Date: 4th January 2023
Our Ref: 5709/sst
Your Ref: DC/22/4046/FUL

**Re: Non-Material Amendment Application to: Single Replacement Dwelling
20 North Hill, Woodbridge, IP12 1HH**

1 South-West Elevation
Scale: 1:100

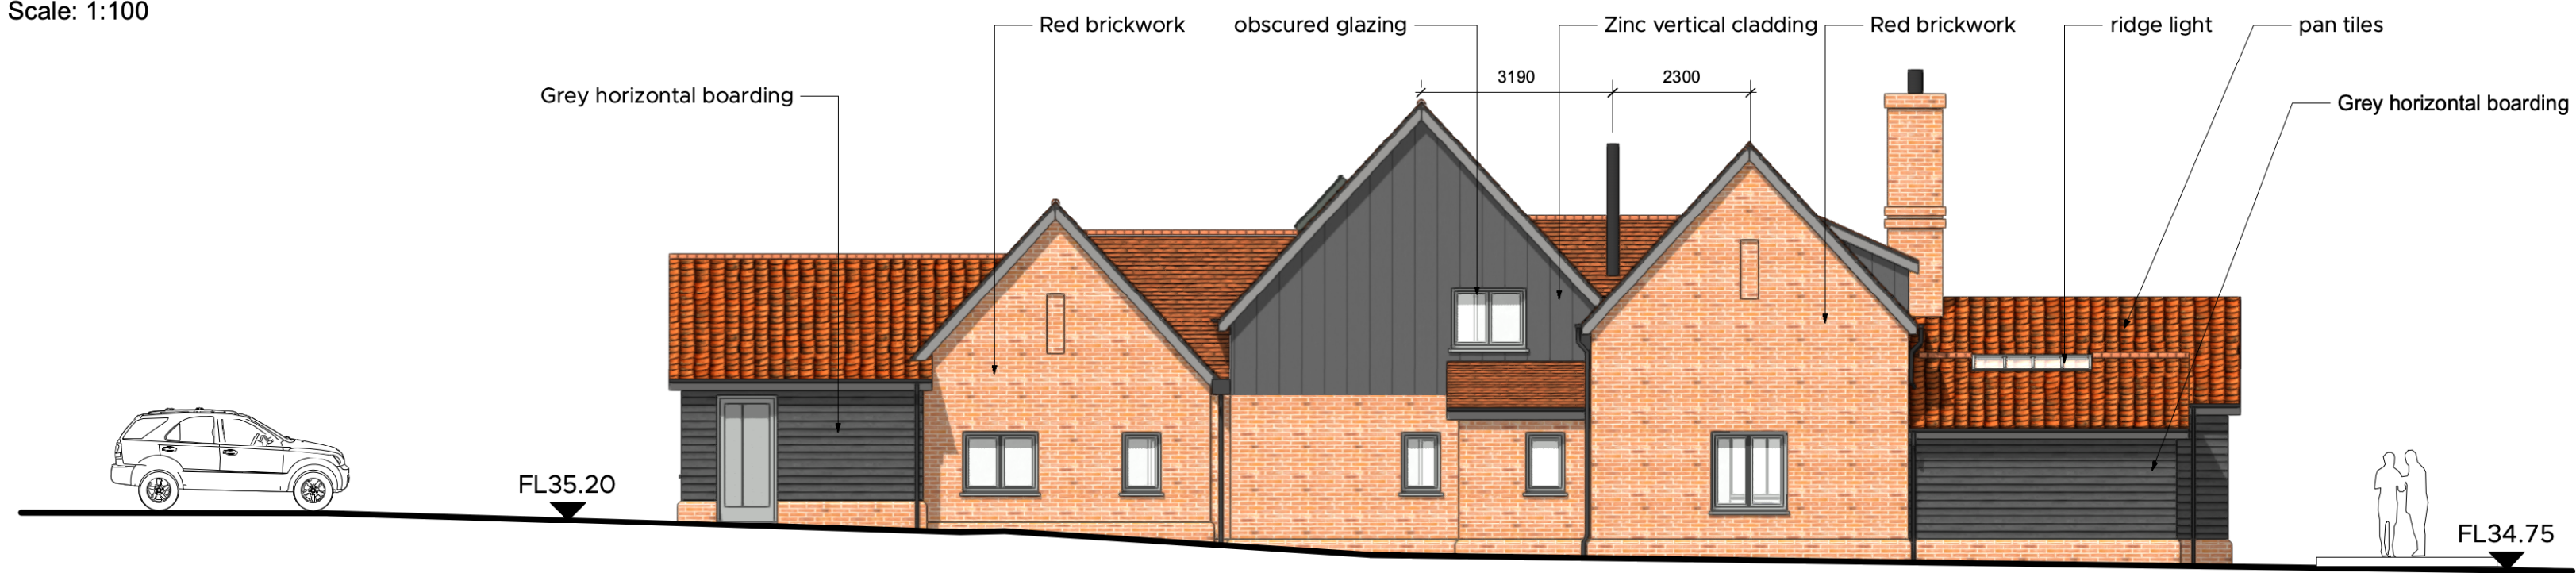
South-West Elevation

7. Door and window replaces door with sidelight to office.
8. Brickwork recess detail in bedroom gable end.

2 North-East Elevation
Scale: 1:100

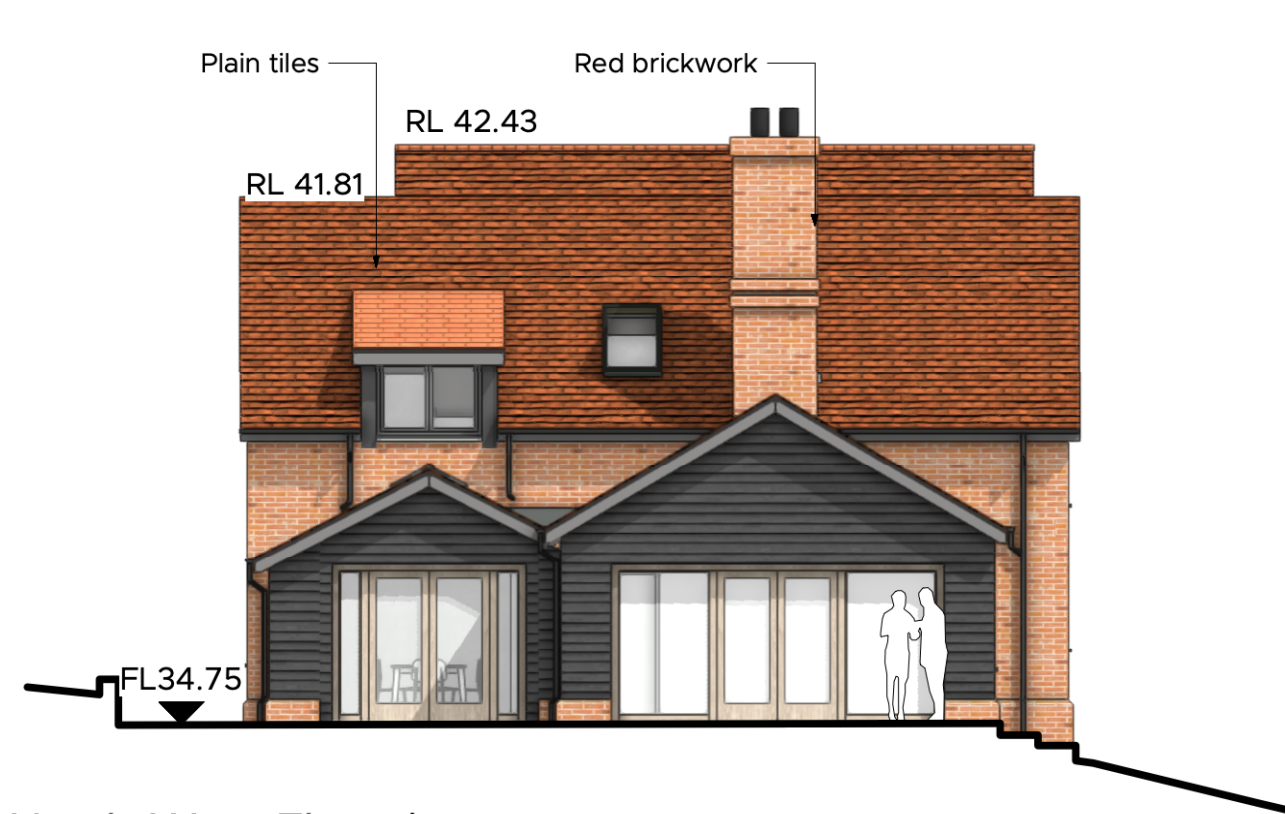
North-East Elevation

11. Window omitted from plant room / store.
12. Zinc raised to first floor on central gable end and obscured glazed window moved from central position.
13. Brickwork recess detail added in gable ends.
14. Metal circular flue moved and raised in height.
15. Window added in office.

3 North-West Elevation
Scale: 1:100

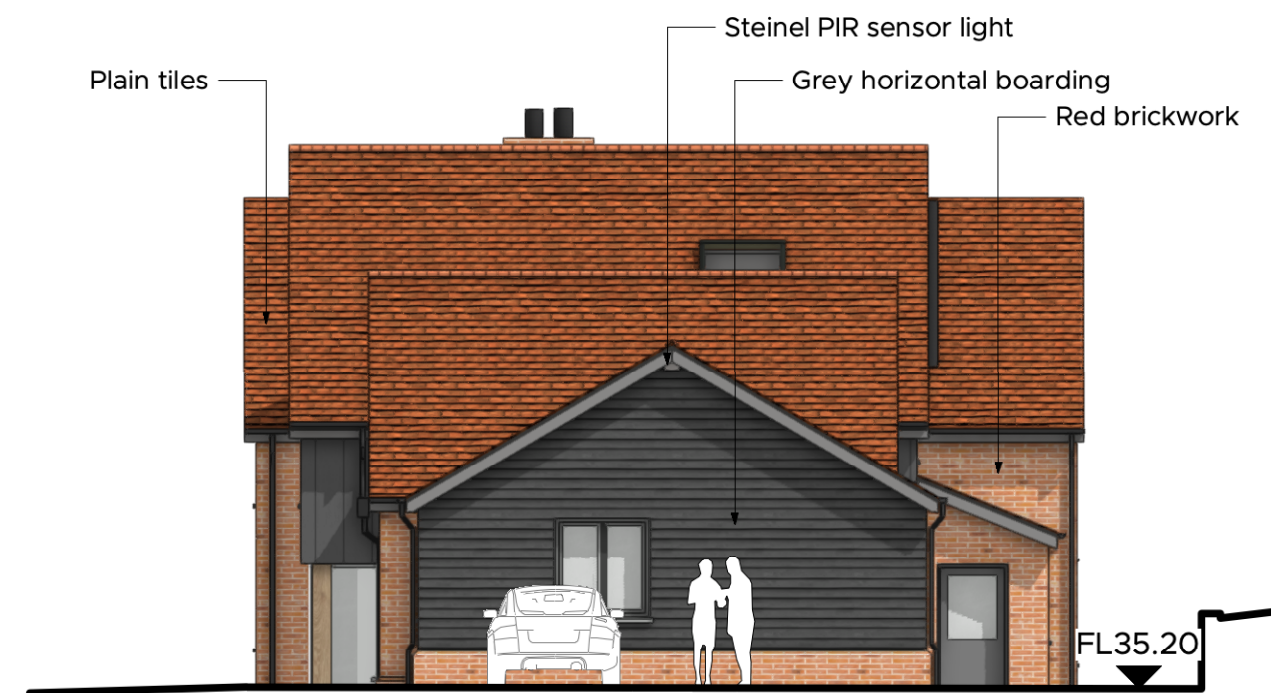
North-West Elevation

9. High level glazing removed.
10. Chimney narrowed.
